Comments on Planning Applications 2021/1089 and 2021/1090

Many of the documents are the same, if with different filenames. Comments are common to both if appropriate.

Figure 3 – Illustrative Masterplan

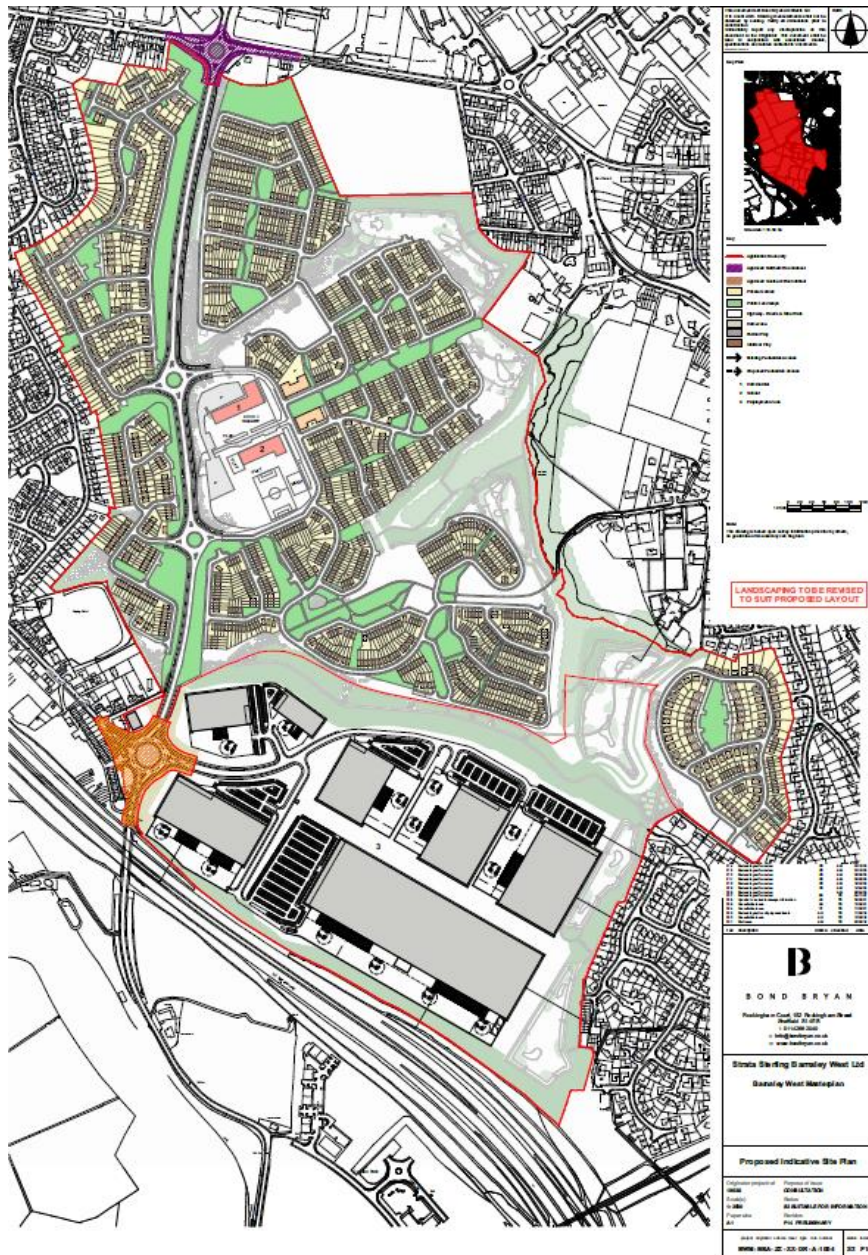
Lack of facilities for Gawber J&I School drop off.

In the original masterplan there was a green buffer behind Wharfedale Road and this should be reinstated.
